LHU/CIR.P16-0421PL.

**Application for Minor-Material Amendment to Condition 2 (approved plans) of planning permission LPA ref: BN/19/16/PL.**

**Land at Former Pollards Nursery, Lake Lane, Barnham, PO22 0AF.**

DCC	Dwg No	Dwg Rev
2	401

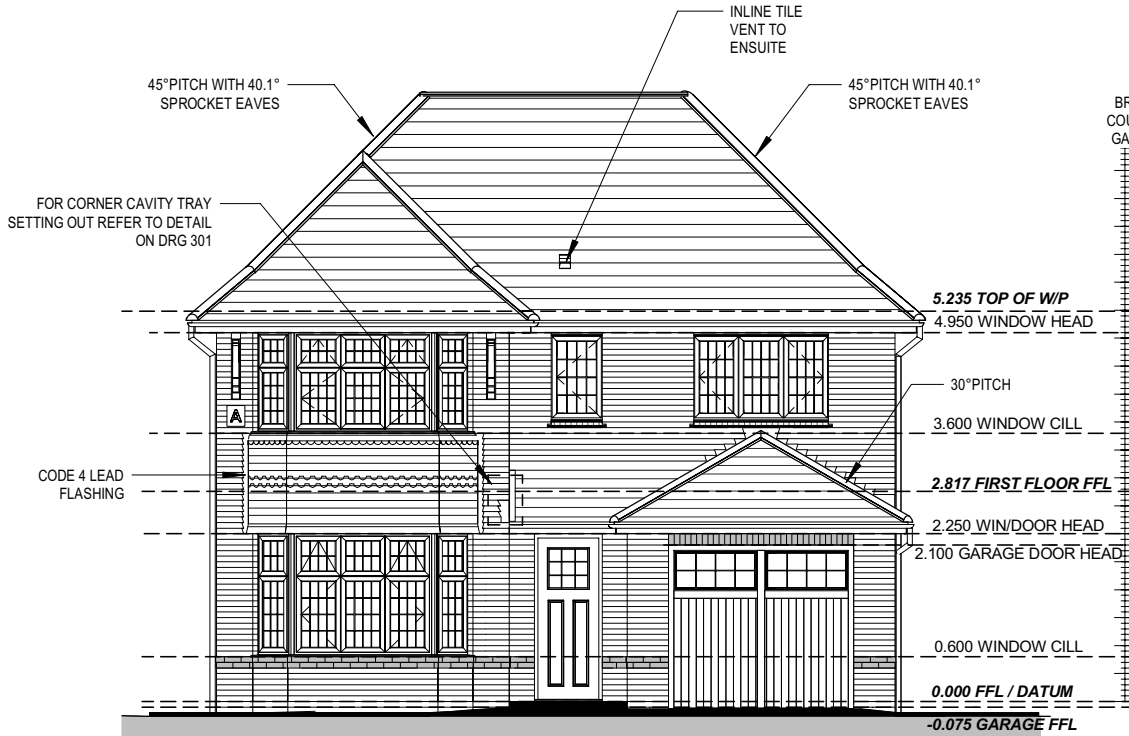
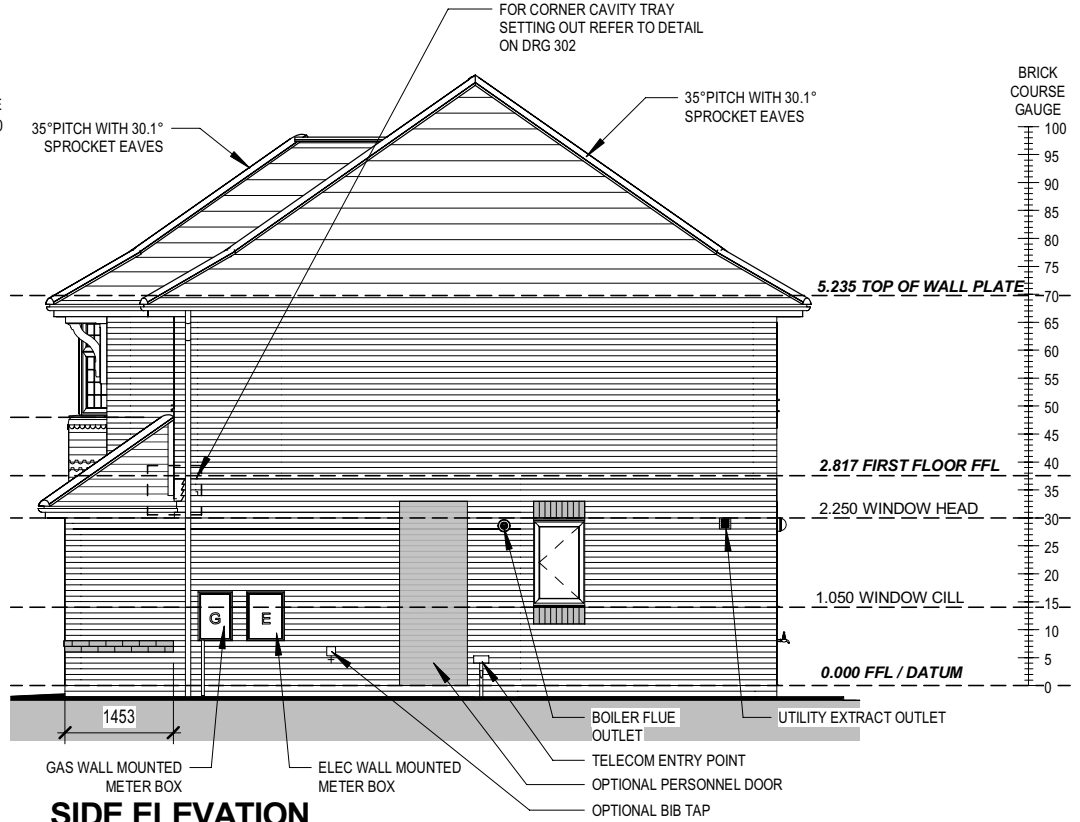
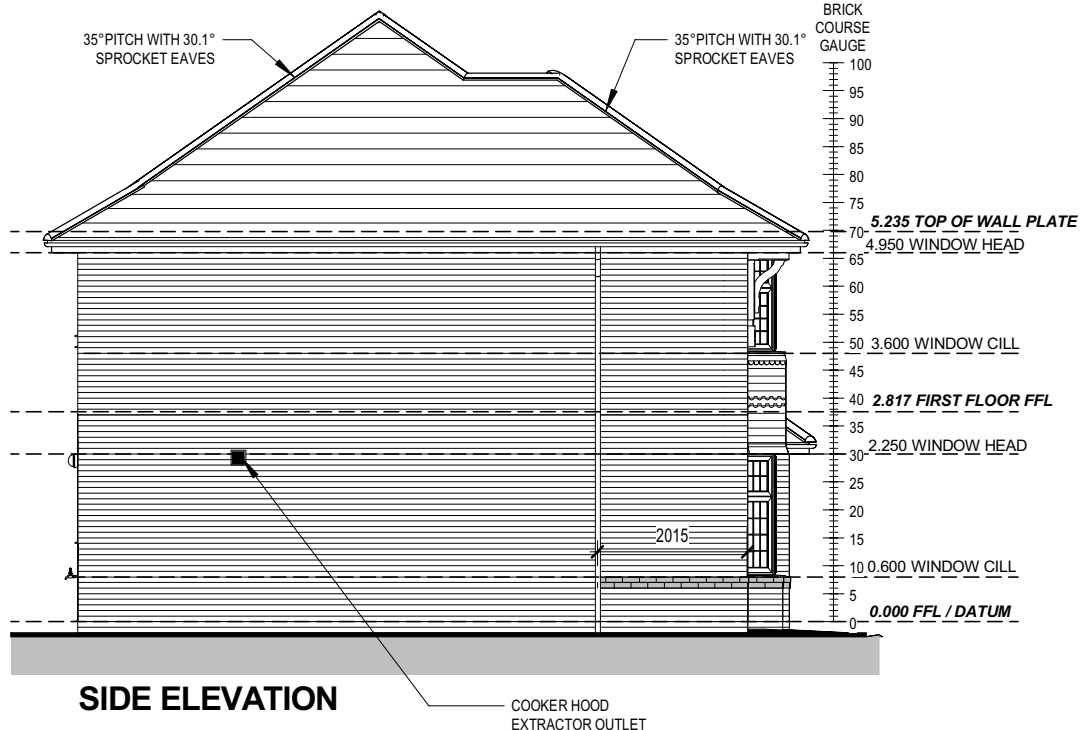
The proposed changes relate principally to Plot 3 and Plot 4. This Minor-Material Amendment proposes that on Plot 3 the previously approved ‘Oxford’ (4 bed) becomes ‘Oxford Lifestyle’ (3 bed), which includes a Gable detail on front elevation. While on Plot 4 the previously approved ‘Worcester’ (3 bed) becomes ‘Oxford’ (4 bed).
